2022 Financial Assurance Estimate Form (with pre-plat construction)

PROJECT INFORMATION		
The Cottages at Mesa Ridge	Date	4/1/2022
	PCD File No.

Financial Assurance Forms_v1 redline.pdf Markup Summary 5-12-2022

CITY OF FOUNTAIN CONSTRUCTION DOCUMENTS  
OUTLET STRUCTURE MODIFICATION PLAN

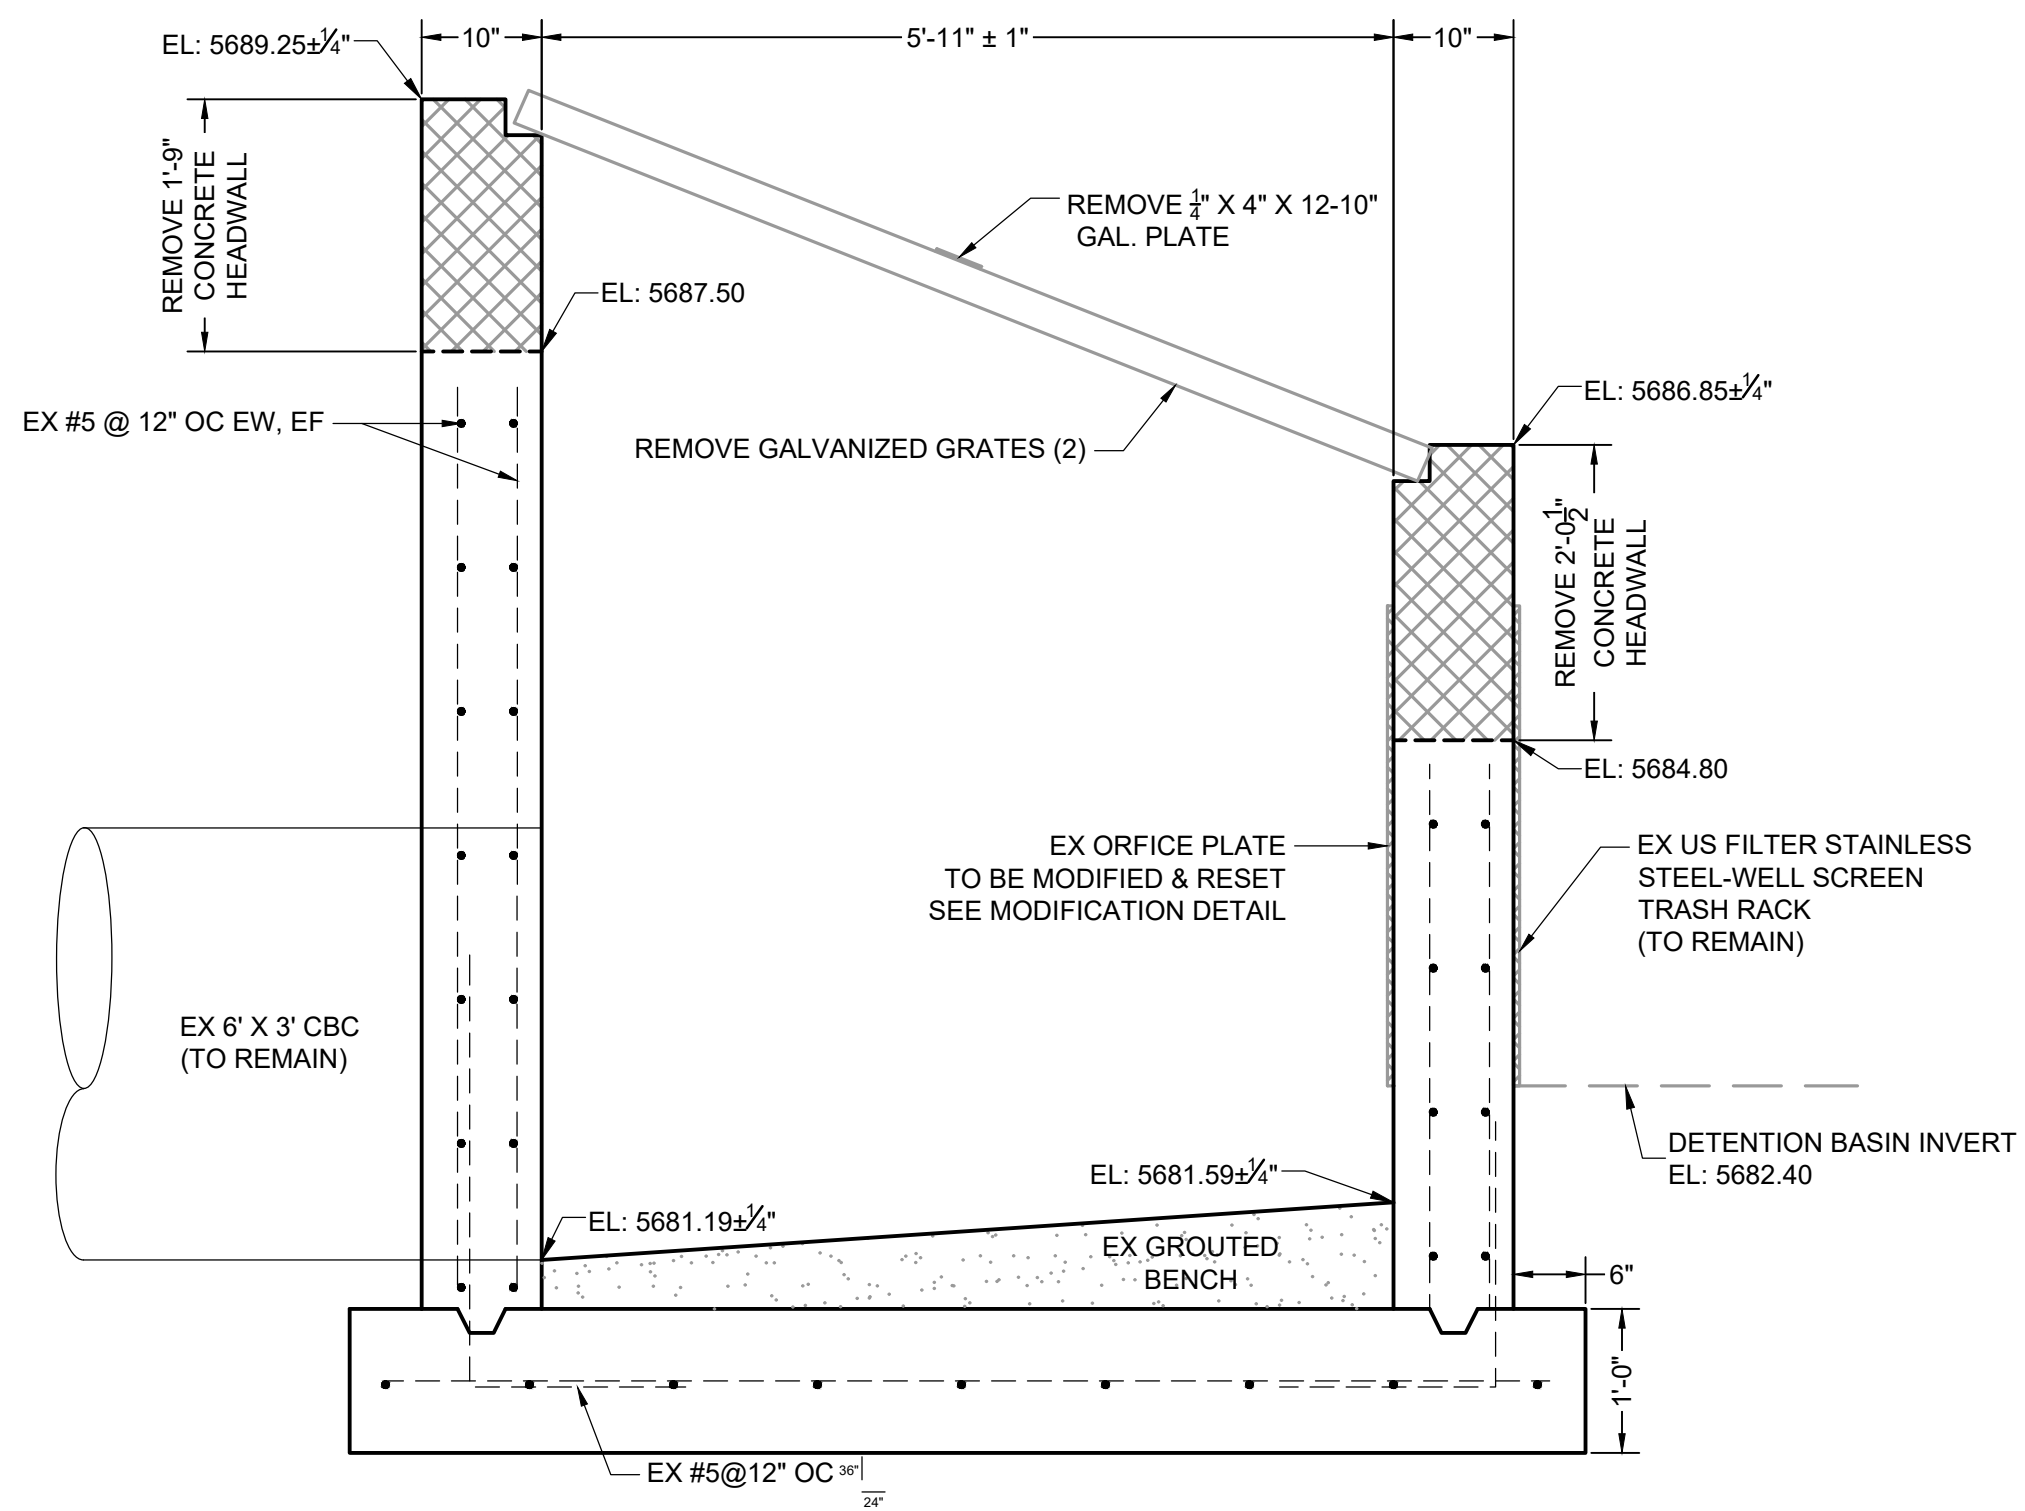
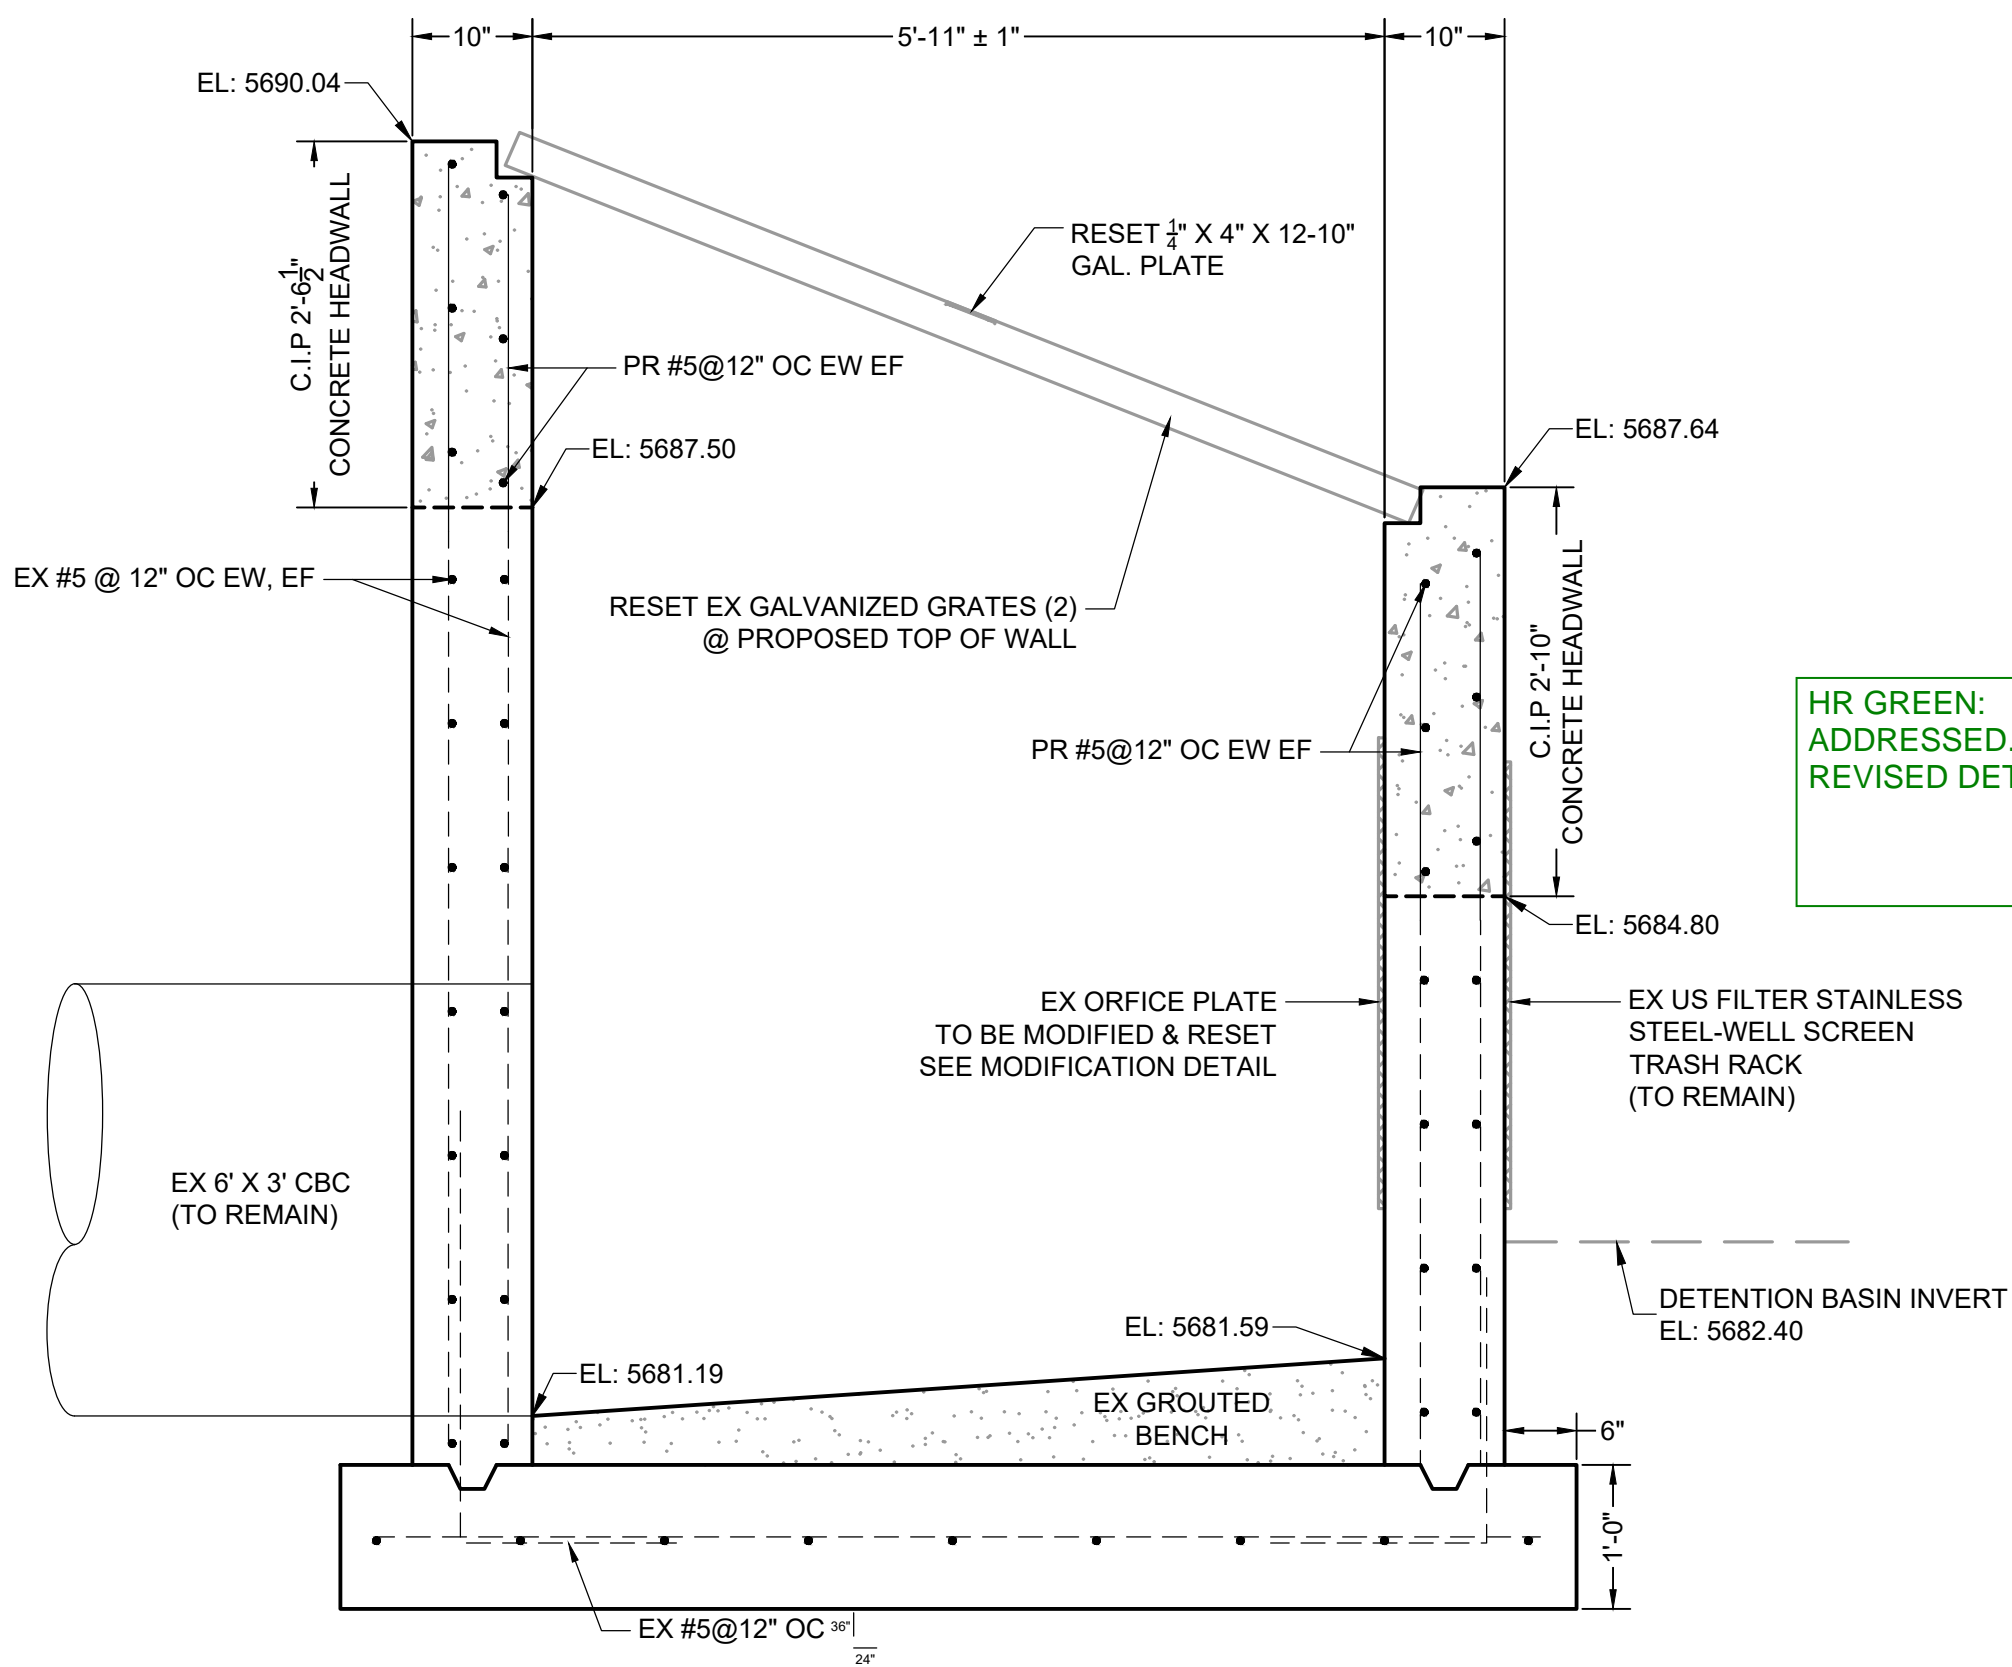
include outlet structure retrofit

HRG RESPONSE: ADDED TO SECTION 3
